File Ref: SSD-27208140_RTS

25 May 2022

**RE: Response to Submissions
St Aloysius College - Rozelle Campus
Property: 2A-2B Gordon Street & 48 Victoria Road, ROZELLE**

Figure 12: Pick Up and Drop Off Location

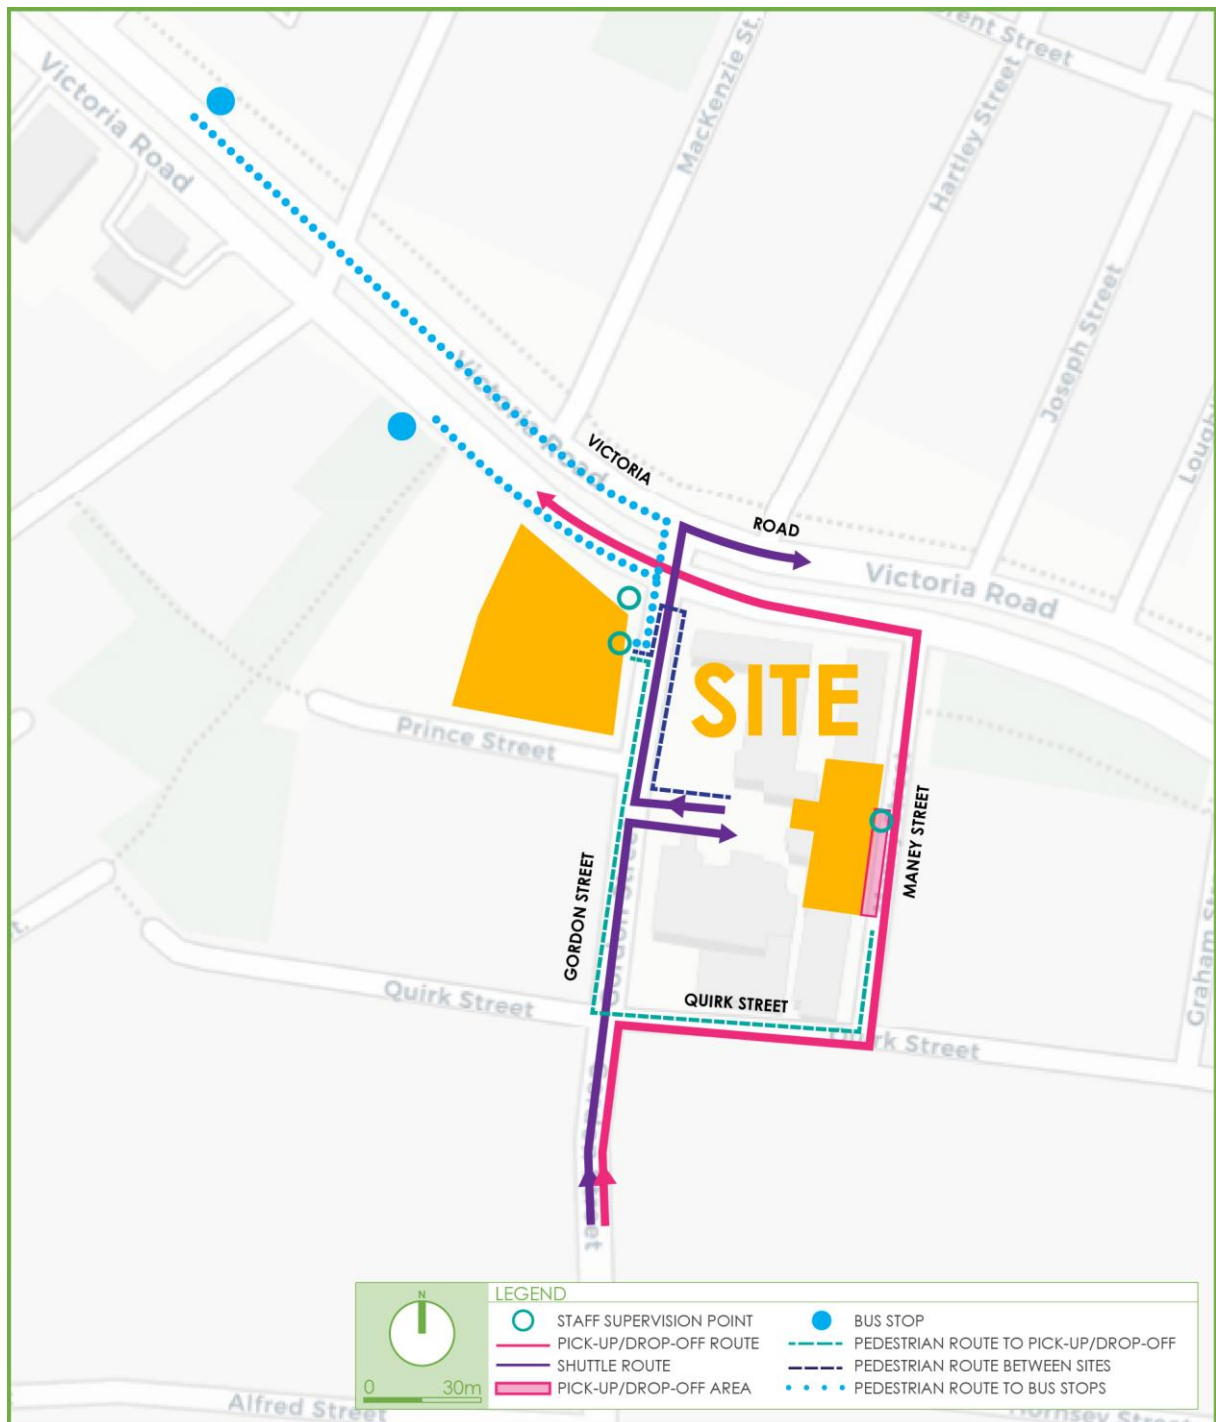
- i. The proposed pickup and drop-off arrangements in Maney Street remain an issue. Even with the relocation of the area to the north in Maney Street, the narrow road width indicates that queuing of vehicles could occur, which will result in the temporary obstruction of the street. Alternatively, the queued vehicles may stay in 'No Stopping' areas at the corner of Maney Street and Quirk Street, which is an issue and could encourage unsafe pickup and drop-off practices. Although the response indicates that the pickup and drop-off areas will be staffed, this area is approximately a 150m walk to the school campus, which may be a challenge to be adequately managed by staff.

Car Park Mark Up p

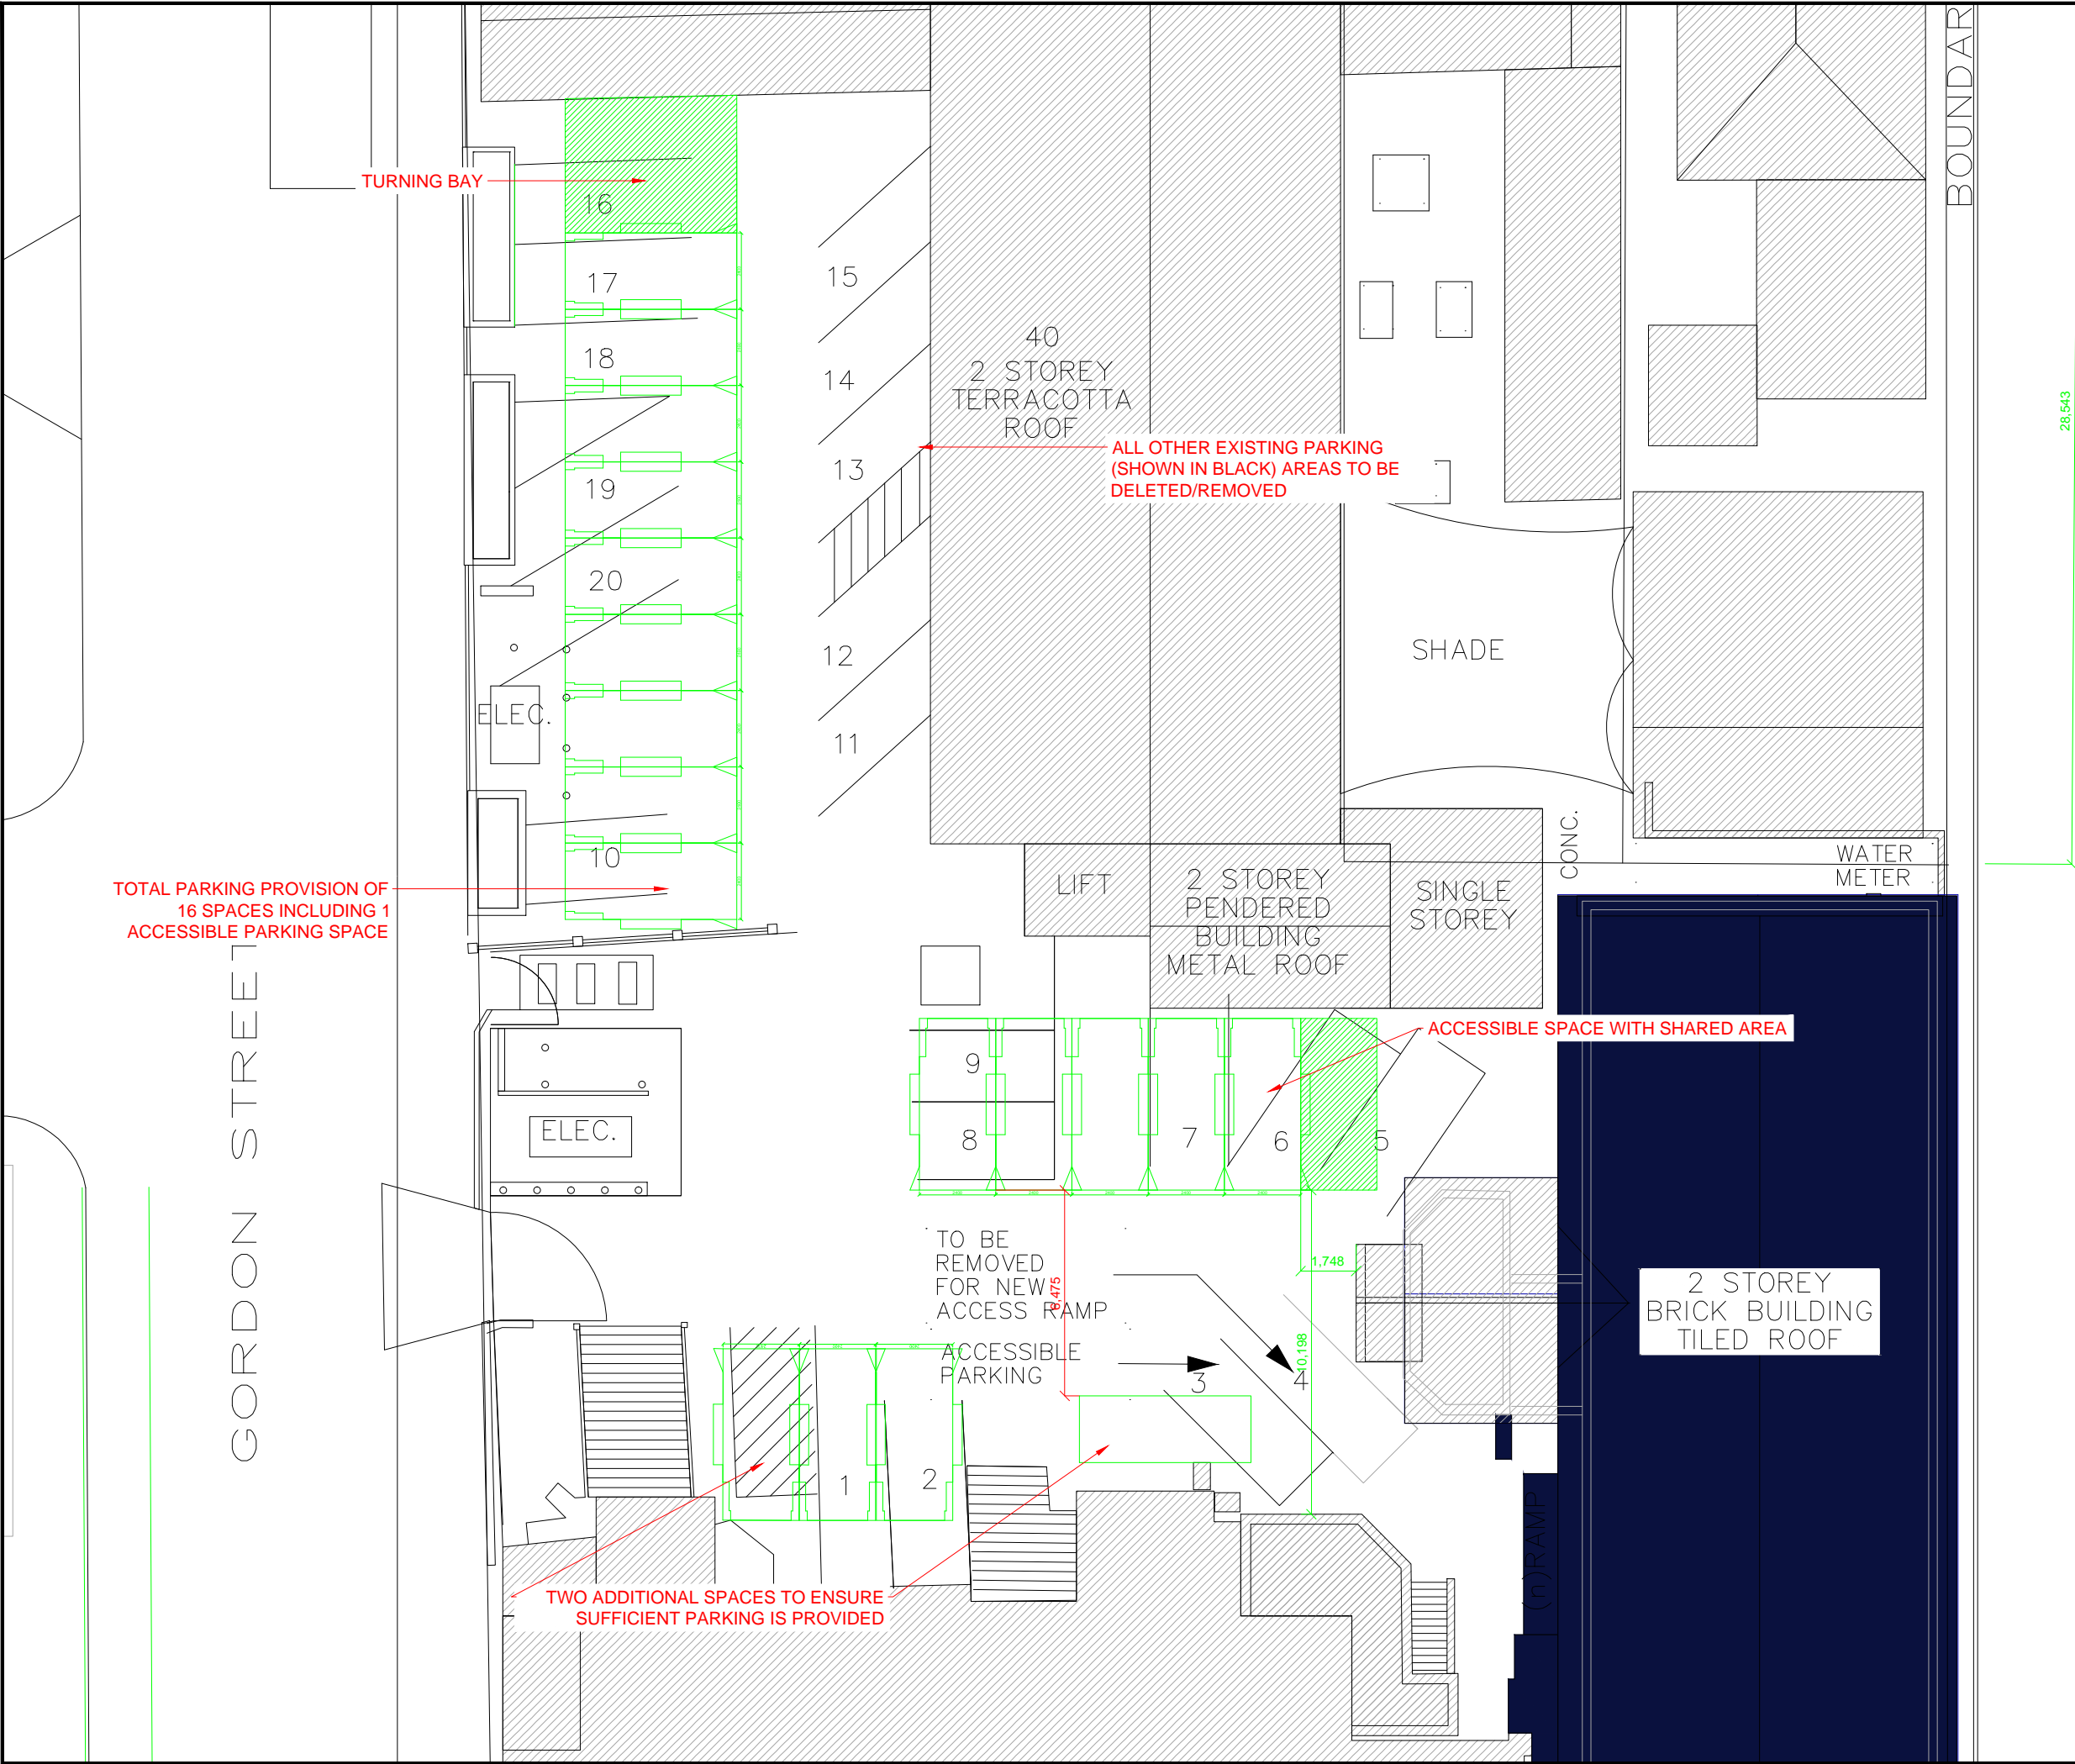
- i. The previous consent on the site required the carpark to be upgraded to comply with AS2890.1:2004. Appendix C of the TAIA details the new compliant layout, which reduces the on-site parking availability from 20 spaces to 16 spaces. However, the TAIA does not acknowledge the reduction in on-site parking and the impact this will have on the off-street parking demand.
